Your reference: SSD-10461  
Our reference: DOC22/390123

**Advice on EIS and recommended conditions – State Significant Development – Valley of the Winds Wind Farm (SSD-10461)**

- Valley of the Winds: Environmental Impact Assessment – prepared by Ramboll Australia Pty Ltd, dated April 2022
- Appendix N: Aboriginal Cultural Heritage Assessment Report – prepared by OzArk Environment and Heritage Pty Ltd, dated April 2022.

Figure 6-1: Aerial showing the areas surveyed.

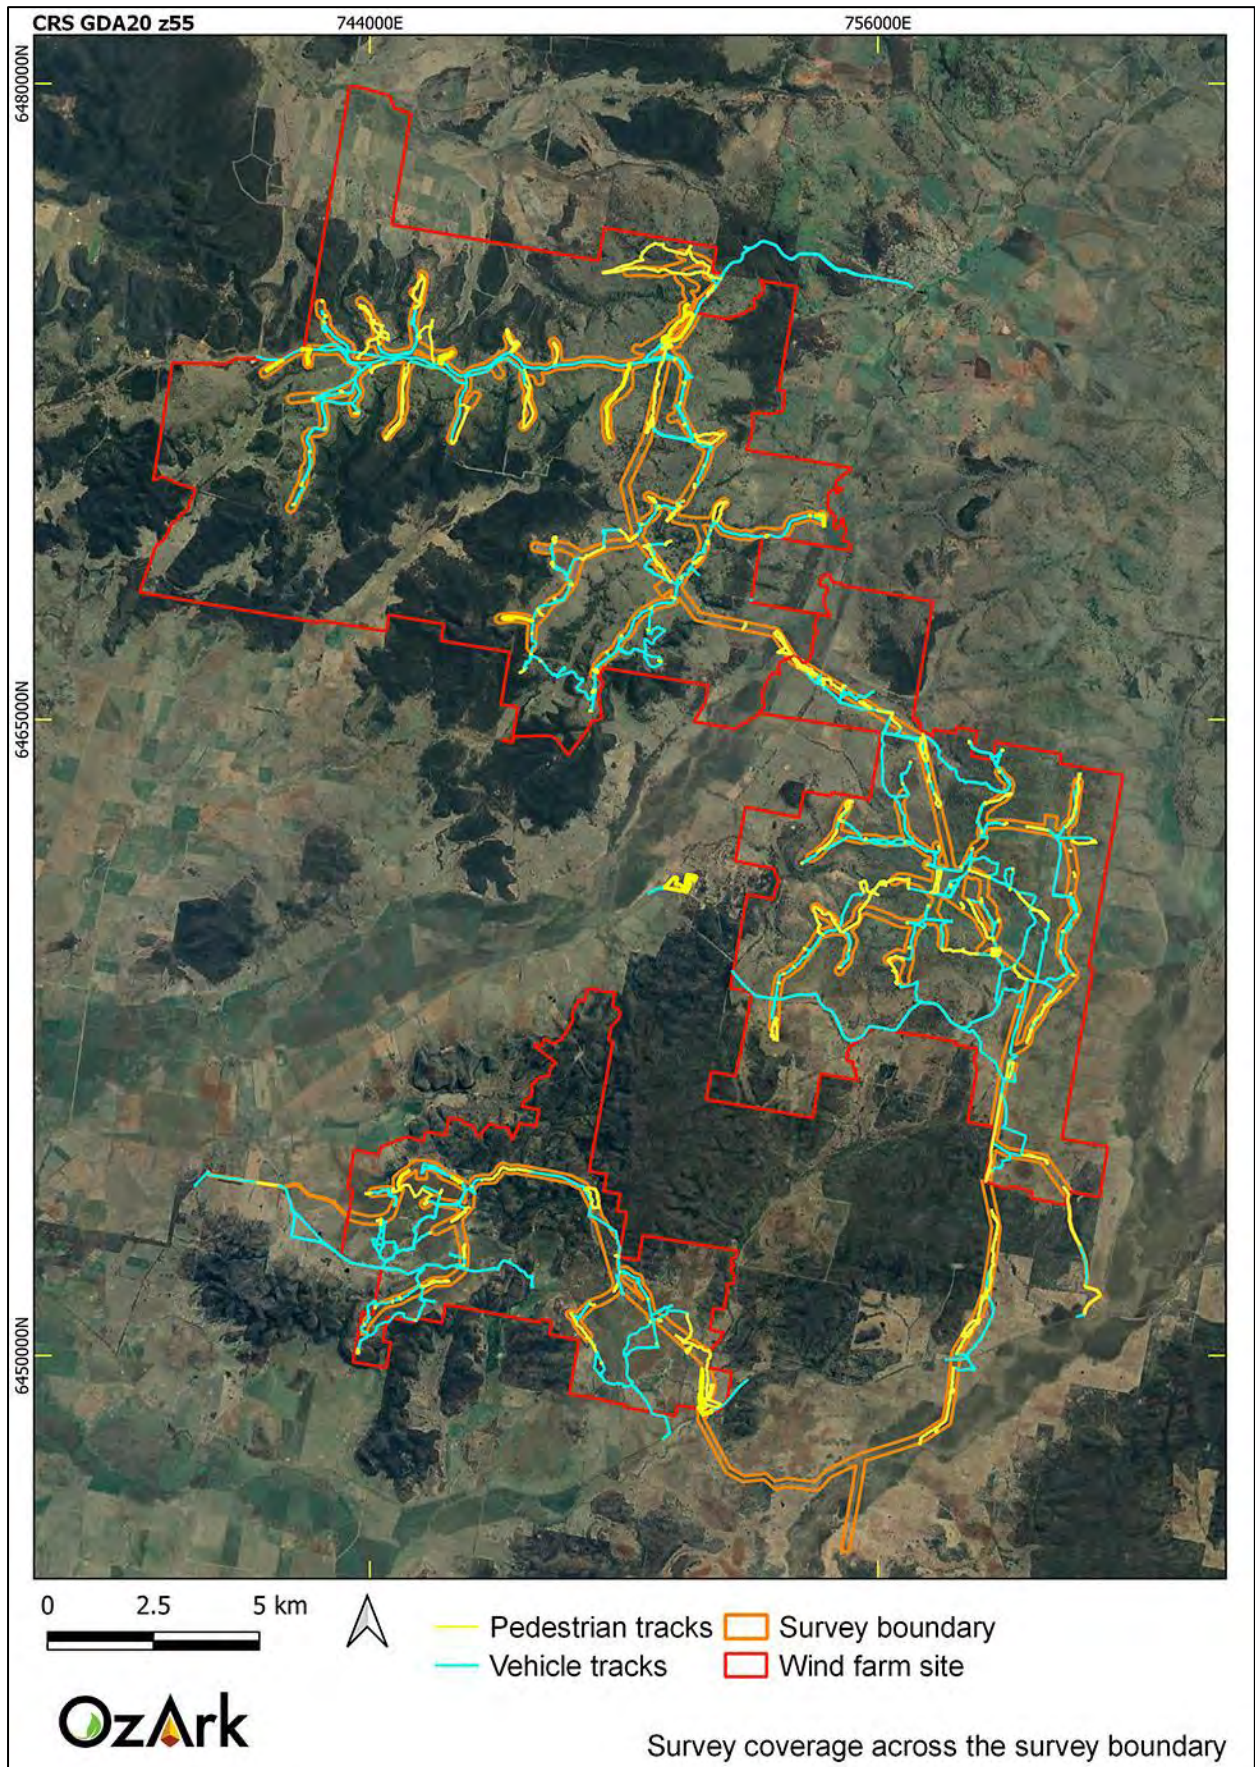
1. Archaeological survey extent needs to be clarified as follows:
  - a. Section 6 and Figure 6-1 of the ACHAR show large sections of the project area that have not been subject to survey or were only covered by vehicle transects. As per Requirement 5 of the *Code of Practice for Archaeological Investigation of Aboriginal Objects in NSW* (DECCW 2010), vehicle traverses are considered reconnaissance activities only and are not equivalent to survey by foot. Survey by vehicle is inadequate for informing the archaeological potential of the area.

- b. Updated figures and tables that include only those areas surveyed by foot and the areas deemed unsafe to conduct survey need to be included in the ACHAR.

- c. If, as Figure 6-1 of the ACHAR indicates, large sections of the project area have not been surveyed then Heritage NSW recommends that these areas are surveyed prior to any project approval.

Figure 6-2: Aerial showing the unsurveyed portion of the survey boundary along the overhead transmission line.

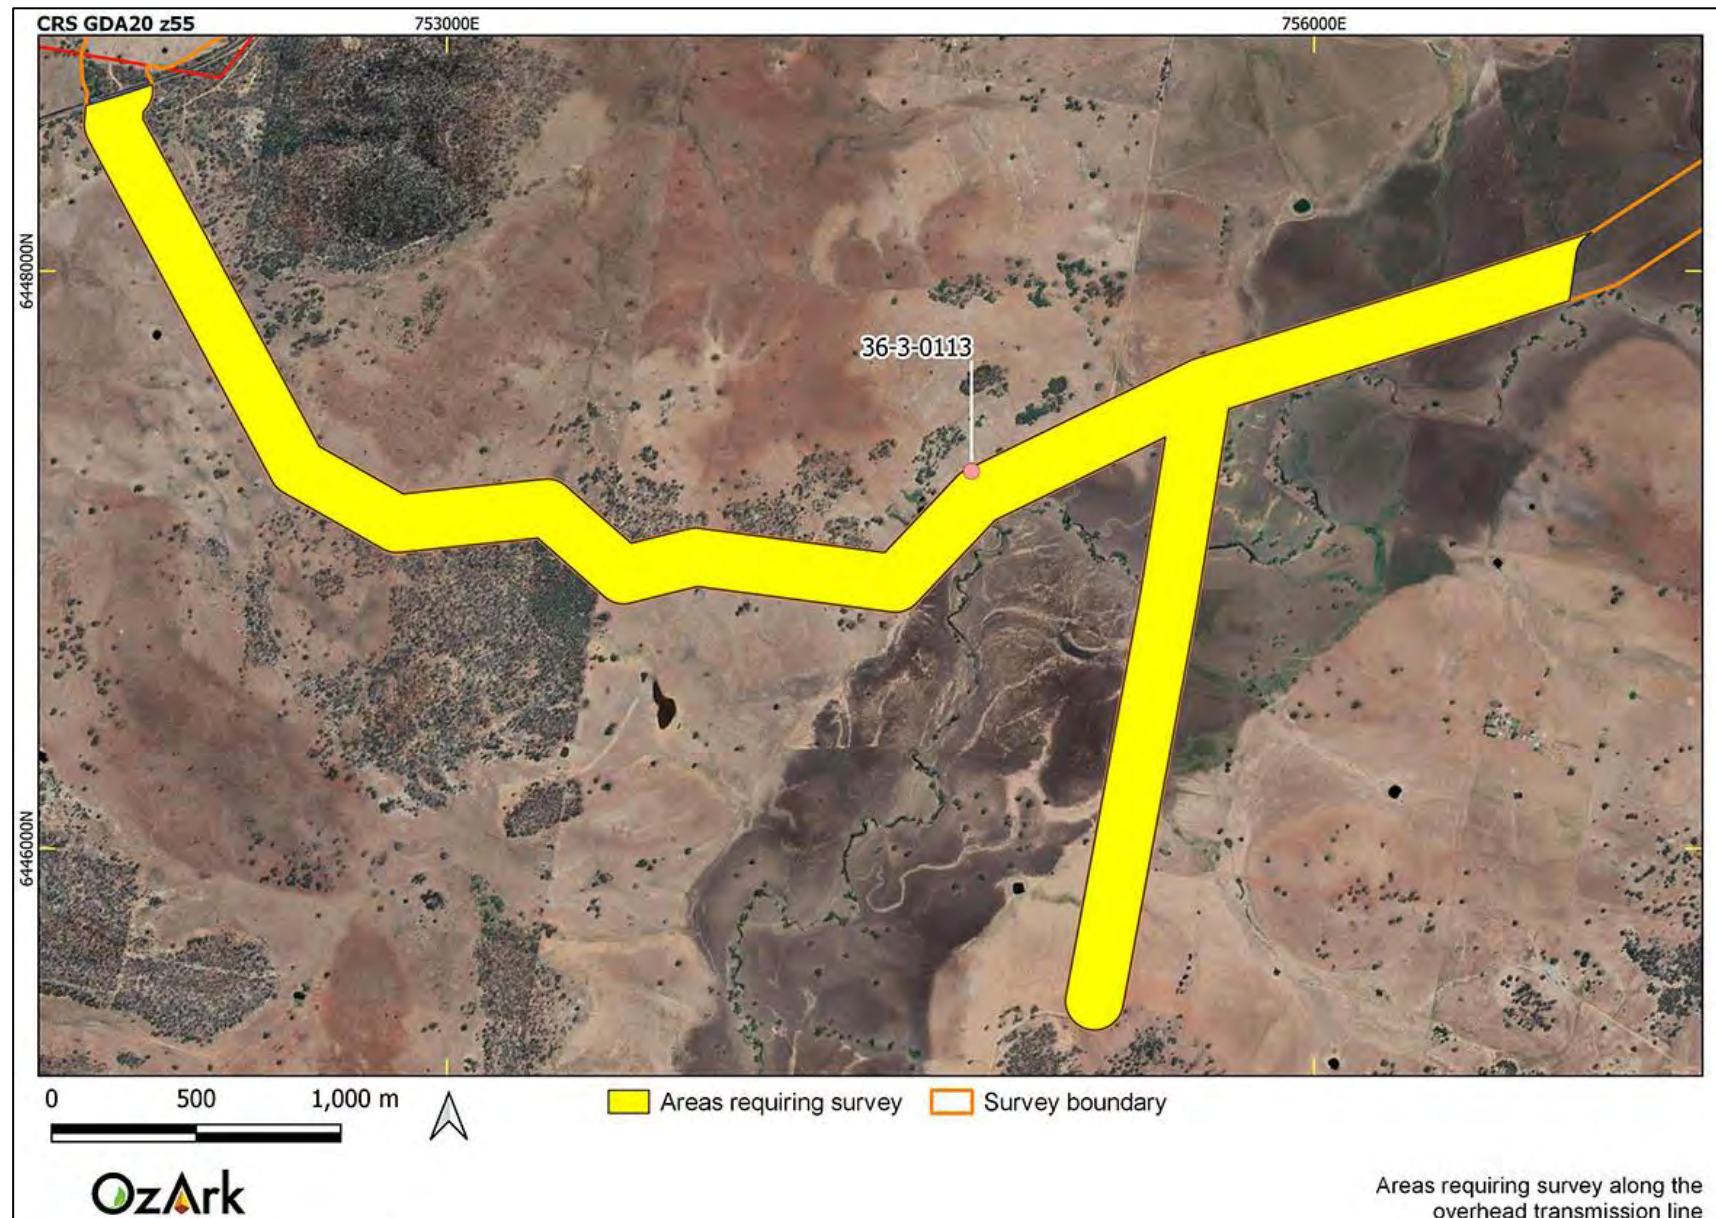
- d. Figure 6-2 of the ACHAR identifies an area that will be subject to survey post-approval. However, this area has been identified as having high potential for Aboriginal cultural heritage. Heritage NSW recommends that this area be subject to survey prior to any approvals to determine whether Aboriginal cultural heritage sites are present that may require project redesign.
